CITY OF ALBUQUERQUE

March 22, 2022

Re: Luminaria Senior Community
10600 Central Ave. SE
30-Day Temporary Certificate of Occupancy
Transportation Development Final Inspection
Engineer's Stamp dated 3-1-22 (L21-D045C)
Certification dated 3-3-22

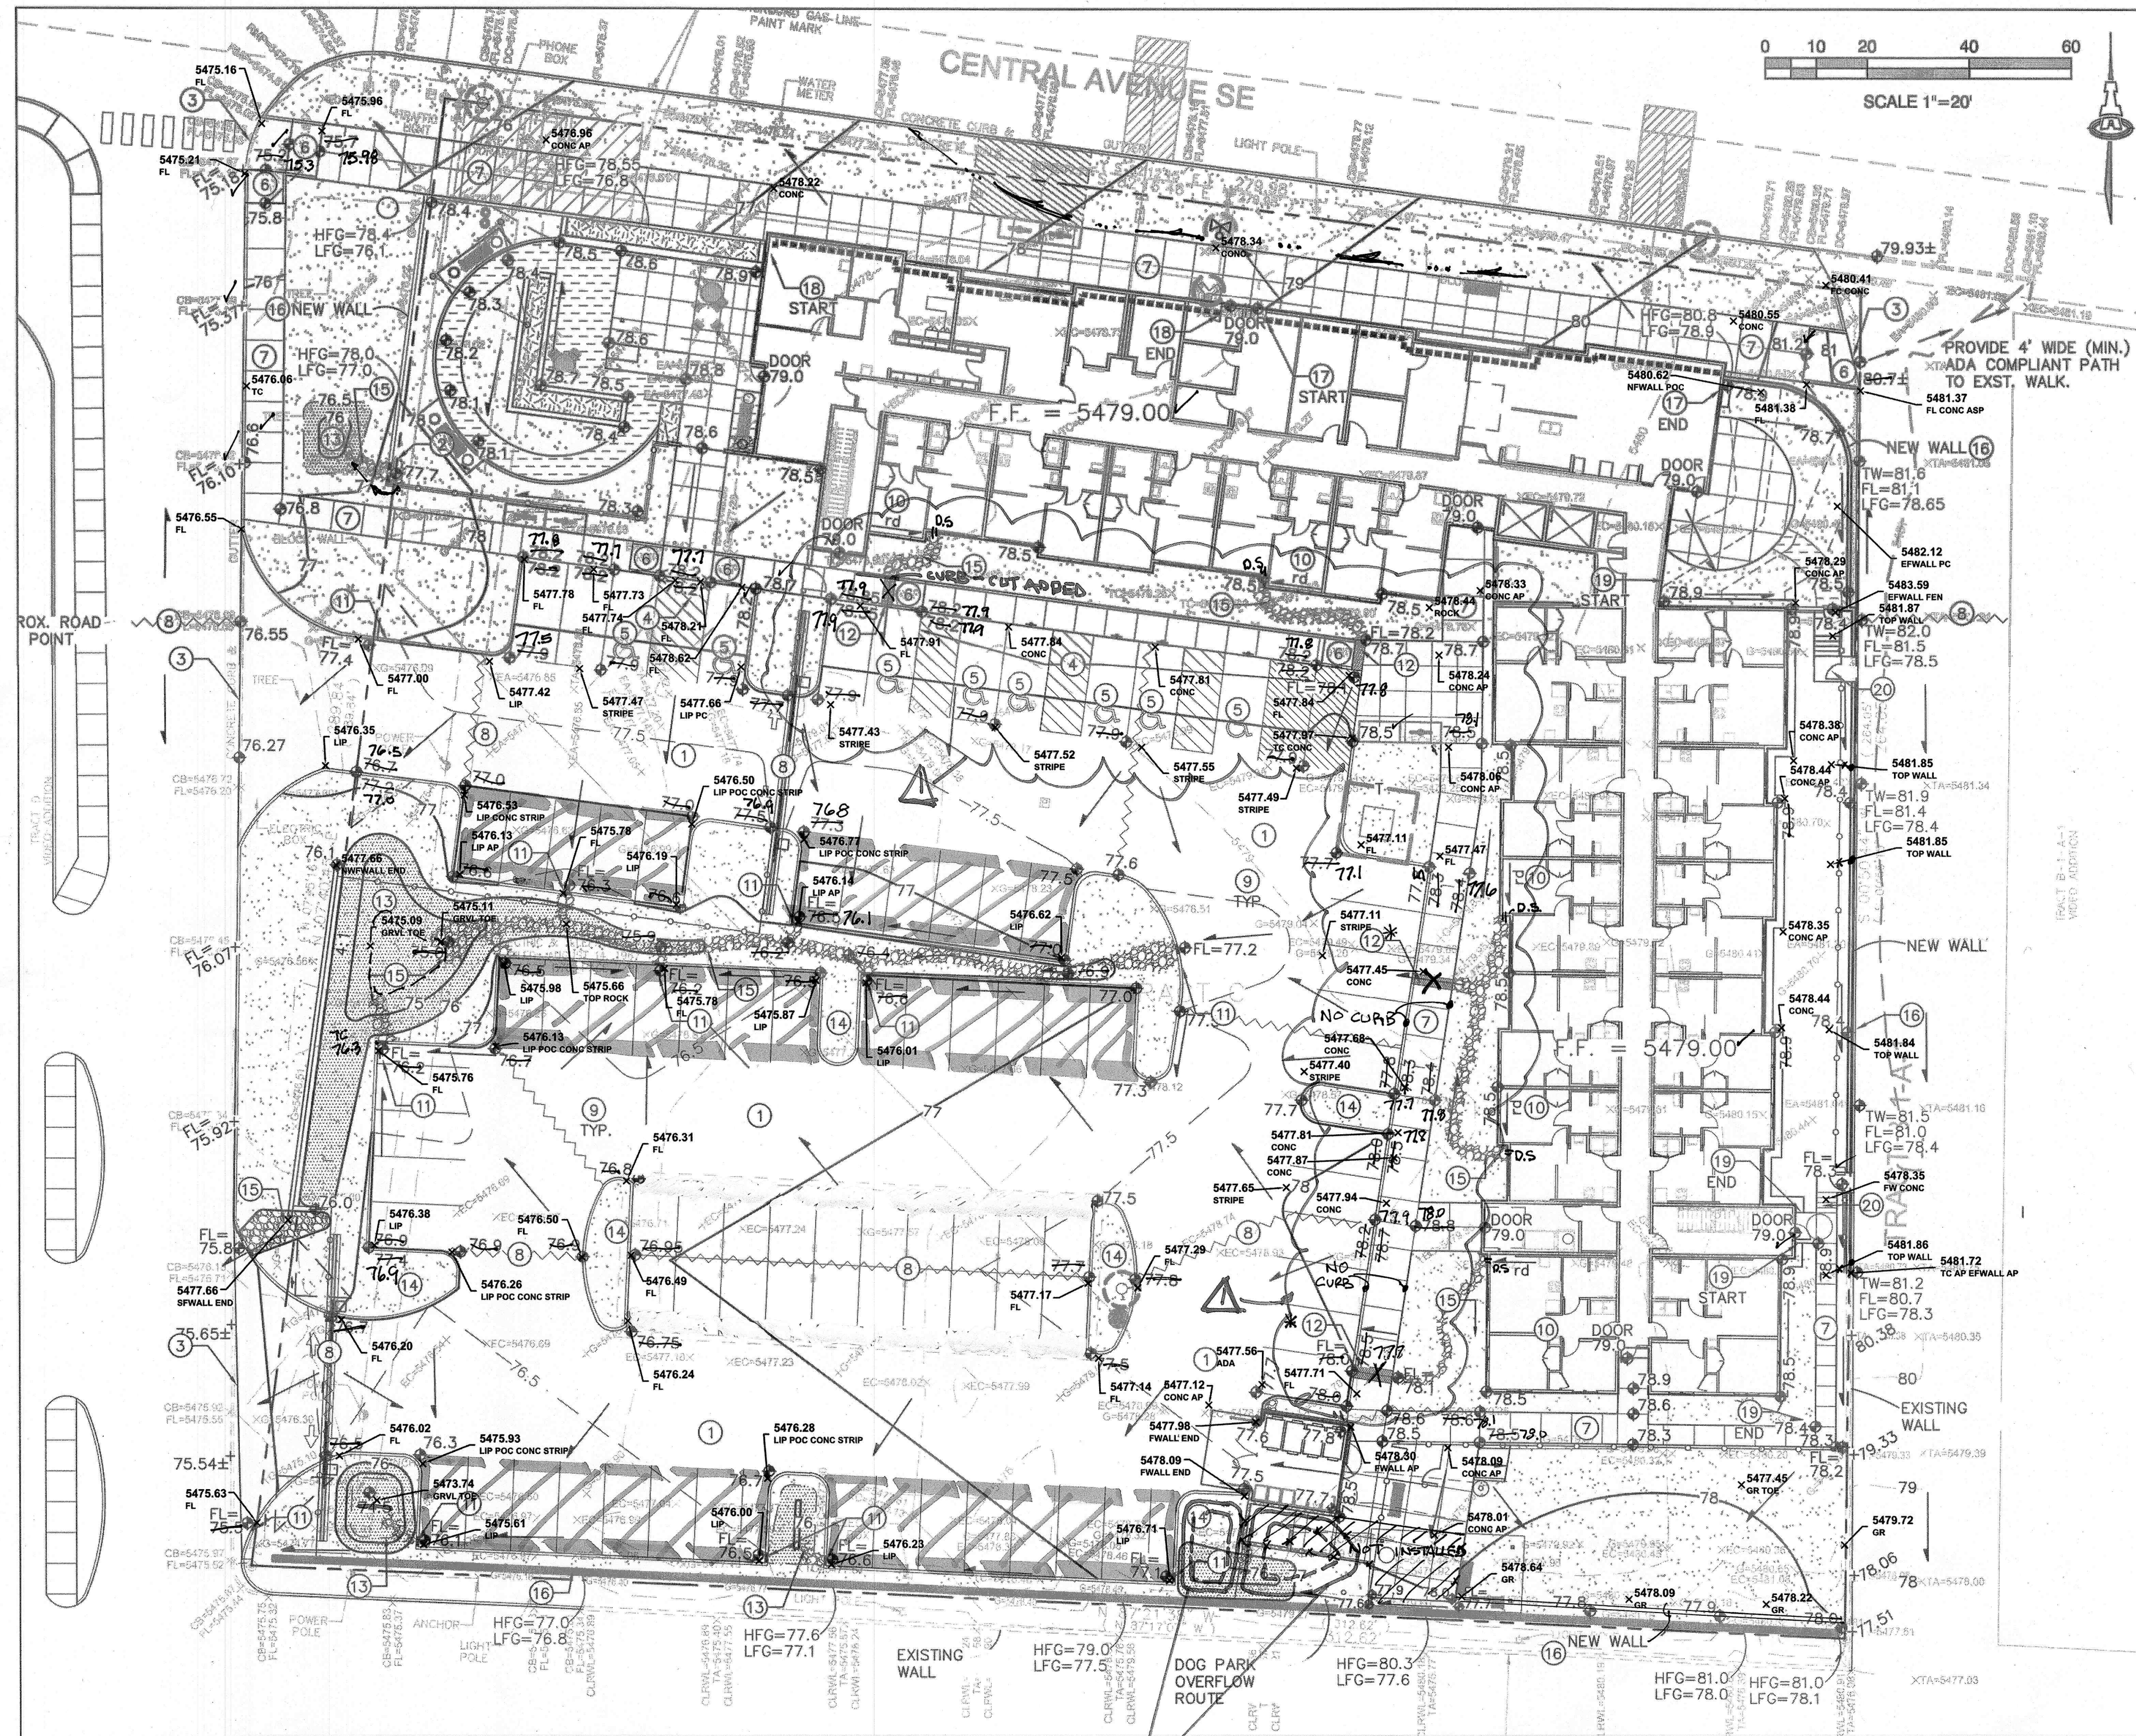
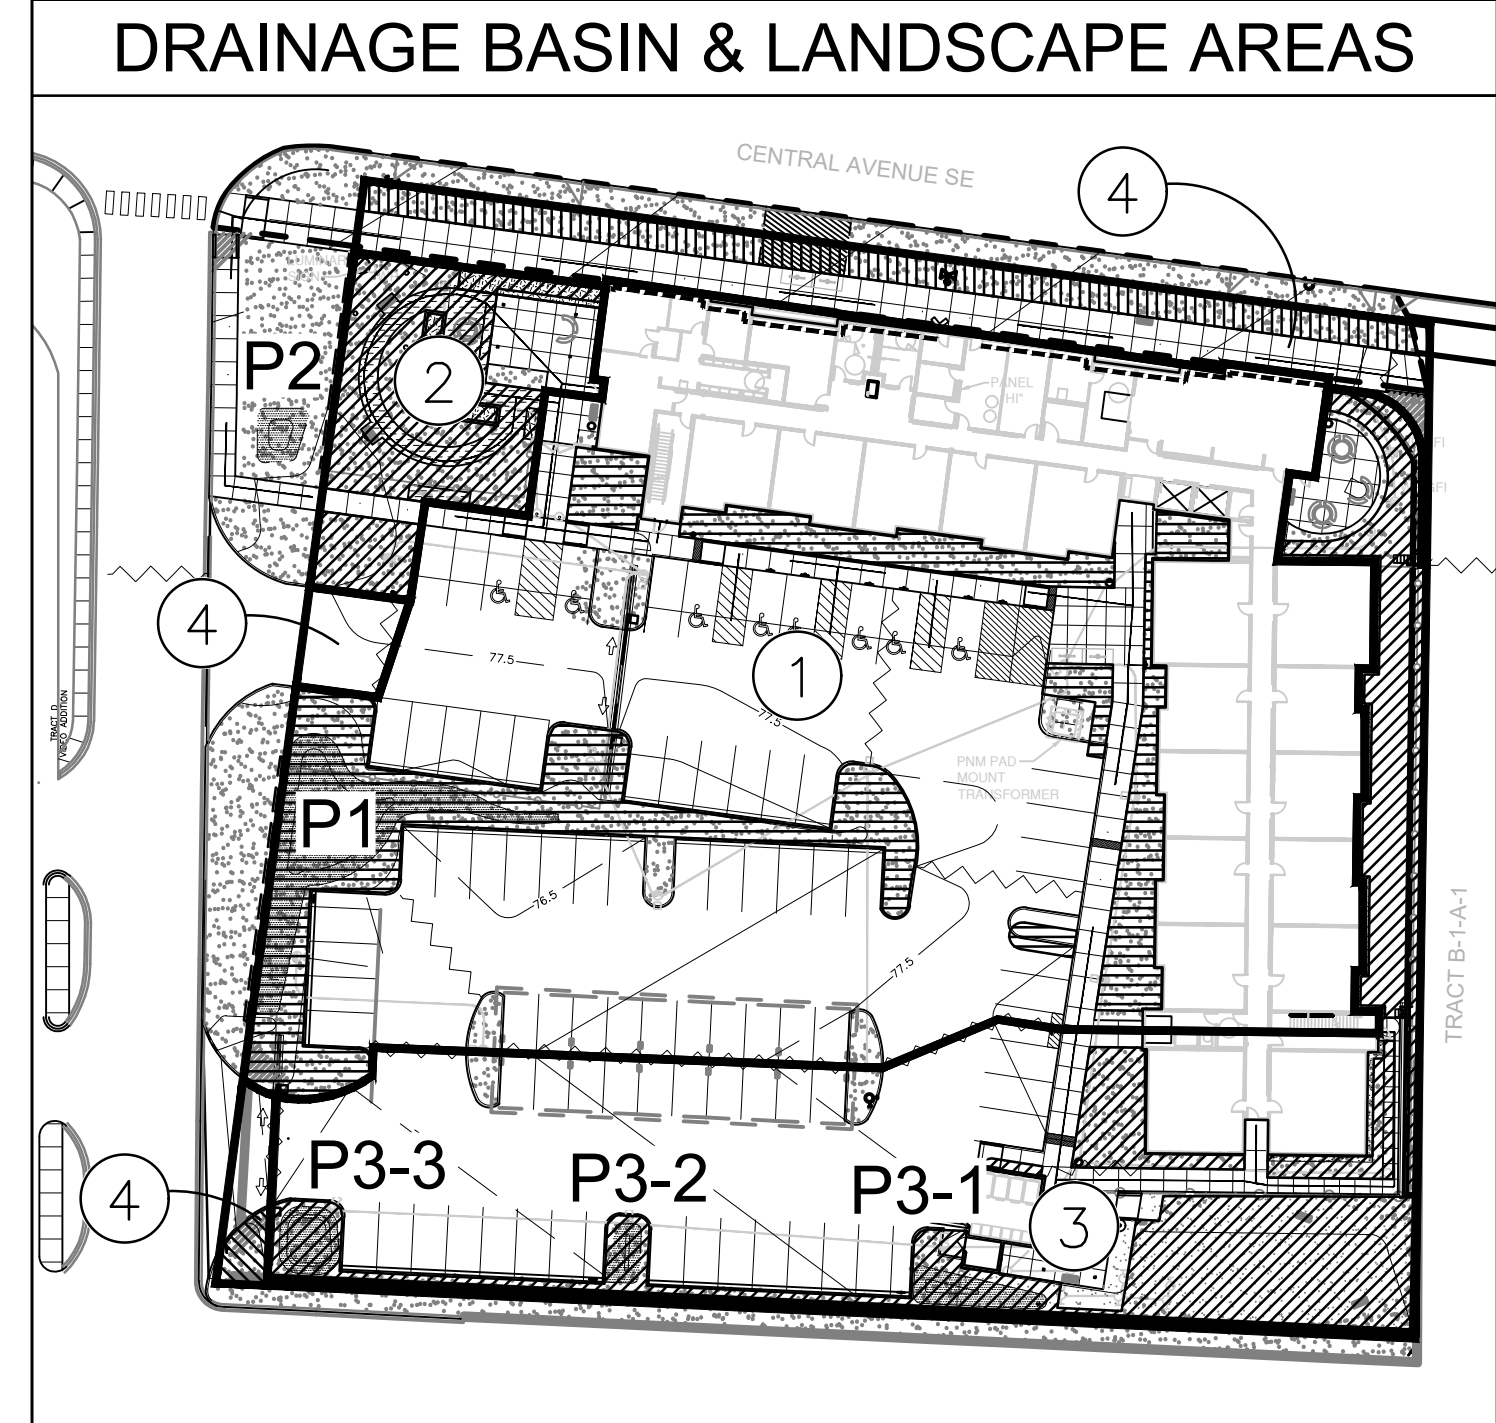
- The width for the ADA Parking spaces at the north side of the site must be 8.5 ft. (per ADA requirements and per approved site plan).
 - Stalls located prior to gate (westside of gate) the access aisle is width is only 45" (needs to be 6 ft in width per COA requirements) and the lip adjoining the asphalt and concrete sidewalk will need to be grid in order to comply with ADA accessibility requirement (**Per DPM, a 6 ft. wide ADA accessible pedestrian pathway is required from the ADA parking stall access aisles to the building entrances**).

- The stalls located after gate(eastside) the access aisle width in only 52" (needs to be 6 ft in width) lip a joining the asphalt and concrete sidewalk will need to be grid down in order to comply with ADA accessibility)

- Concrete sidewalk pathway: a plat is shown on landscaping but no shown on site. This situation will need to be addressed because curbing is broken and landscaping and water is draining directly onto sidewalk and stall access aisle.

- ADA Parking stall at the Westside of the side: The water swells are carrying water and landscaping soil directly onto sidewalk and ADA stalls. This is a concern for ADA accessibility. Please address this concern since there are no curbing to control landscape soil onto sidewalk and stalls.
